STATE OF NORTH CAROLINA
DEPARTMENT OF TRANSPORTATION

June 20, 2013

Subject: **Additional Information in Response to the N.C. Division of Water Quality's On-Hold Letter** for the proposed widening from SR 1003 (North Main Street) and SR 1820 (Skeet Club Road) to NC 68 in High Point, Guilford County; Division 7; TIP U-3615; Federal Aid Project No. STP-1820(2); WBS Element No. 34962.1.1

Reference: 1) Application for Section 404 Individual Permit, Section 401 Individual Water Quality Certification, and Randleman Lake Buffer Authorization, April 25, 2013.
2) NCDWQ On-Hold Letter, dated May 31, 2013, received June 17, 2013.

SITE 8

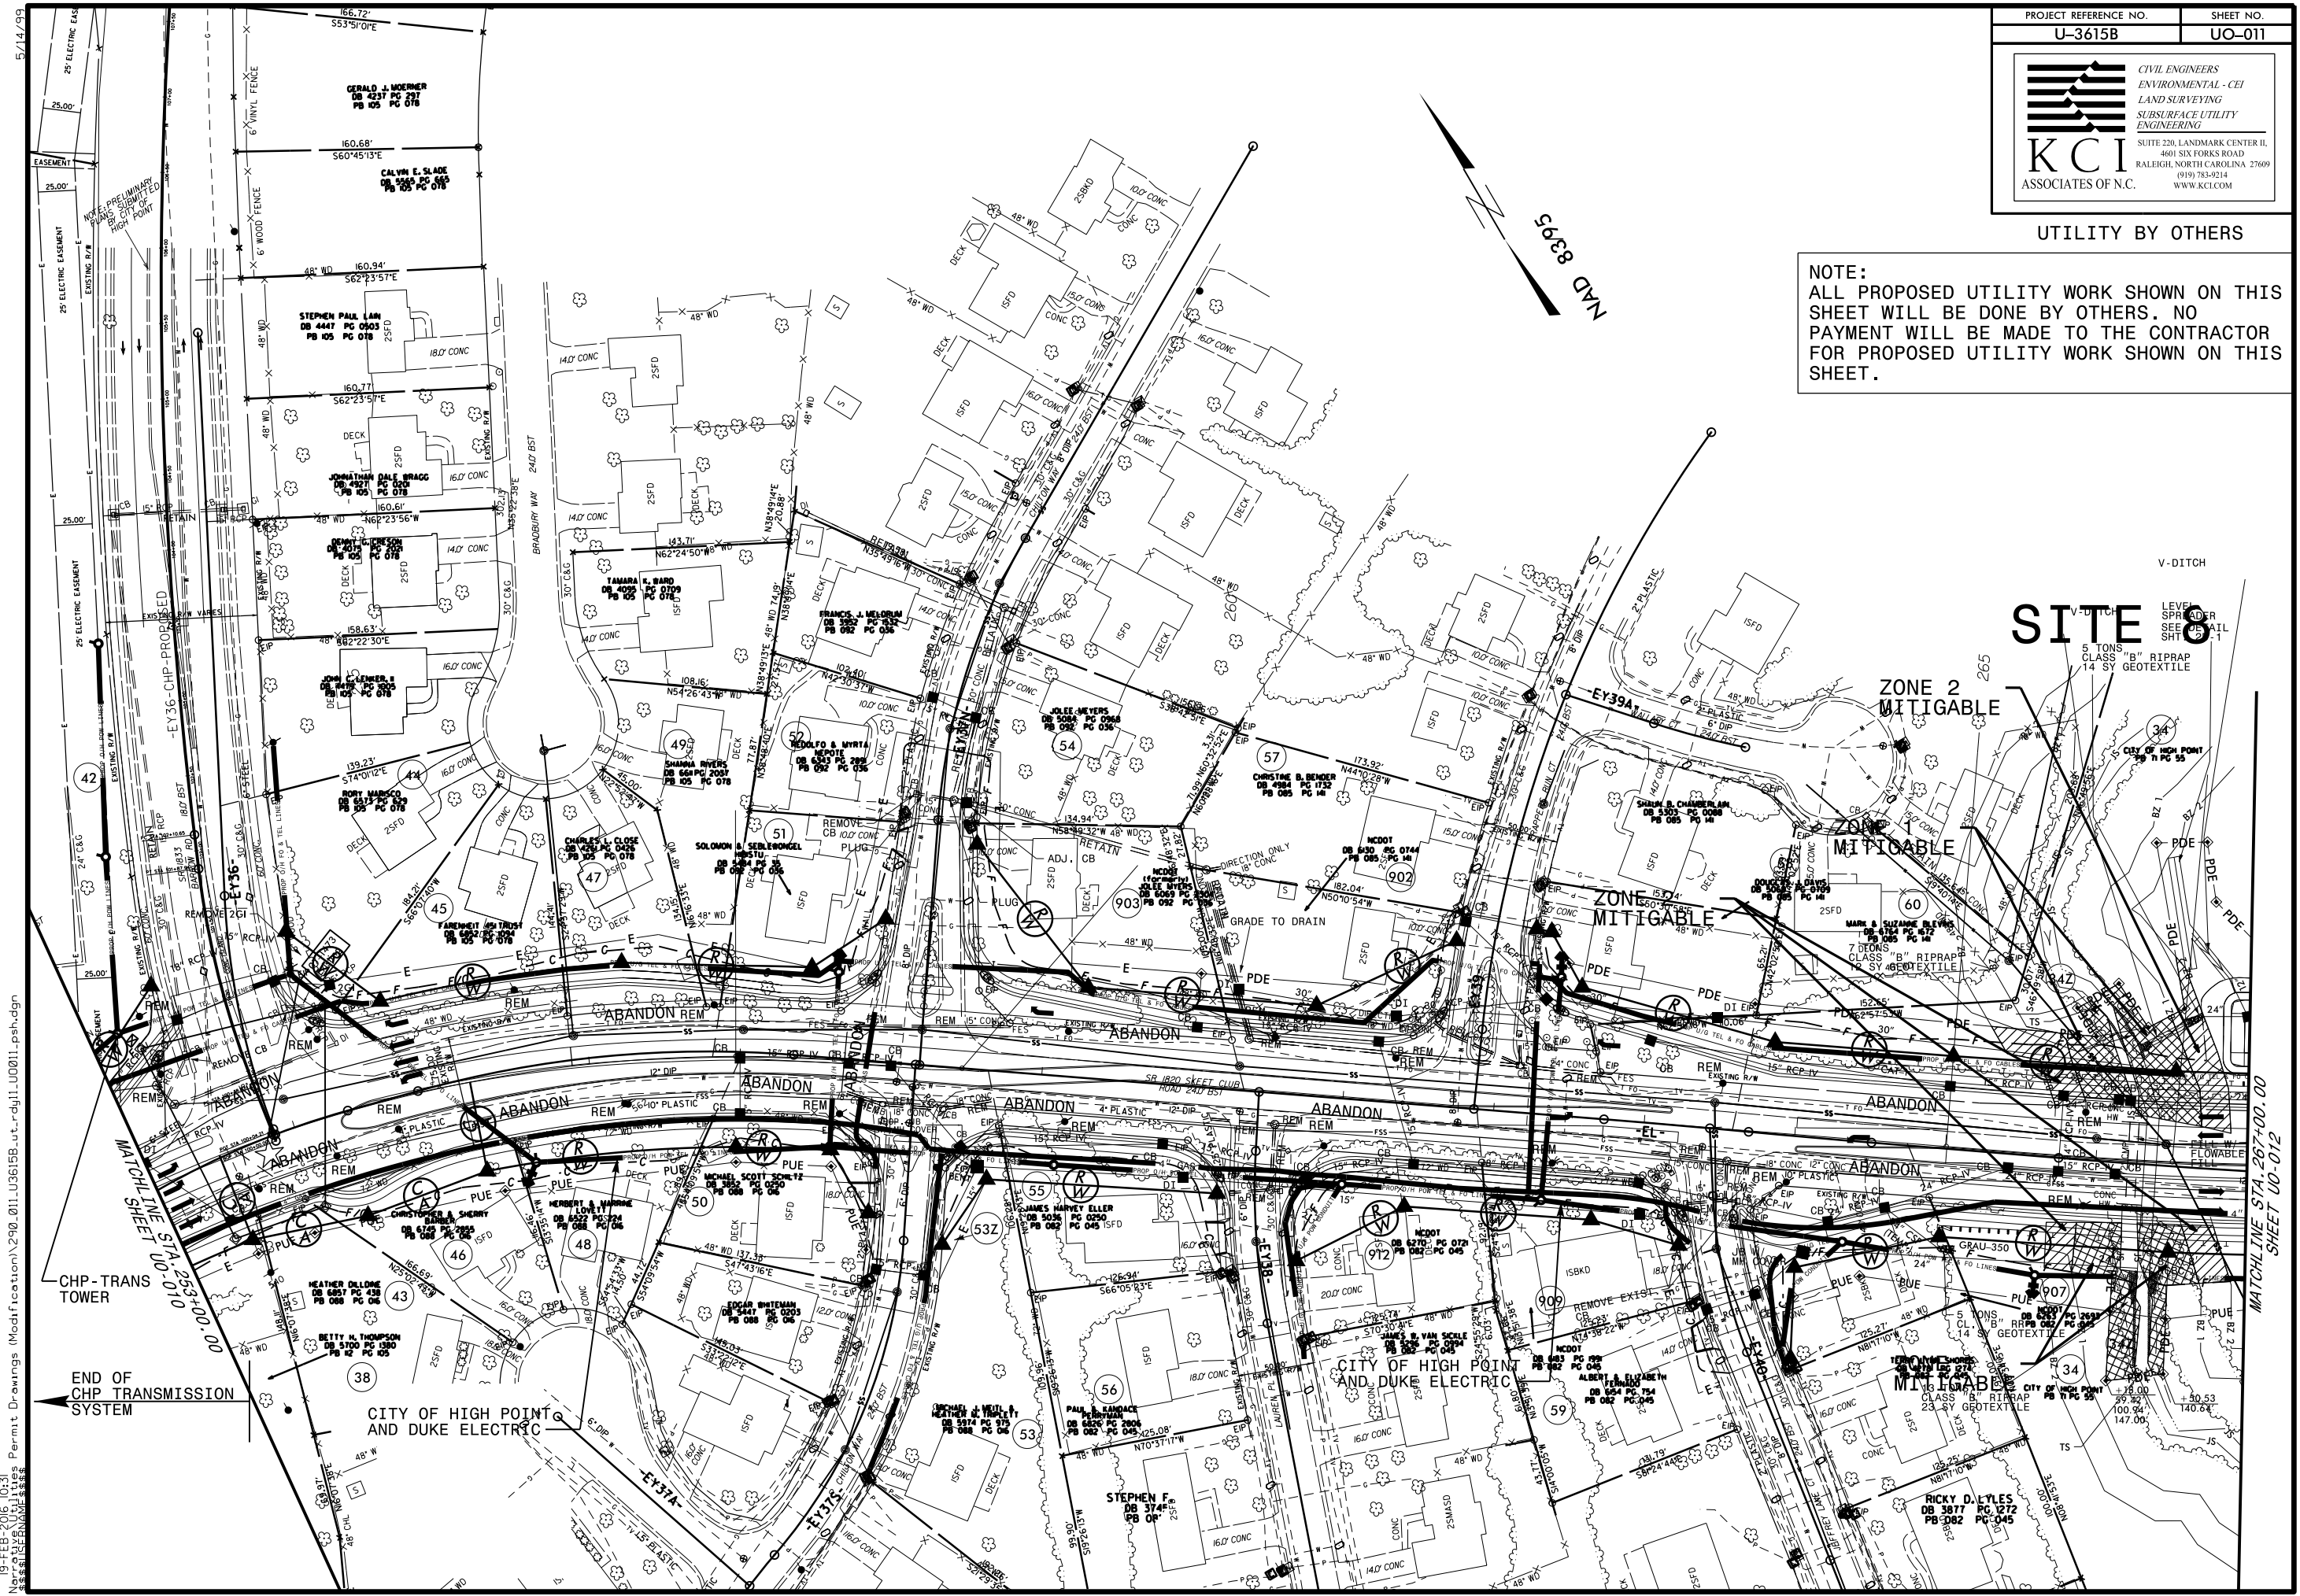
15. At site 8, buffer impacts associated with the overflow channel, should be calculated separate from the crossing impacts.

Based on a telephone conversation, May 23, 2013, between Shawn Harris (Hydraulics Unit) and Amy Euliss (DWQ), the impacts shown at site 8 are shown correctly and are acceptable, since the buffer impacts are caused by the RCBC construction.
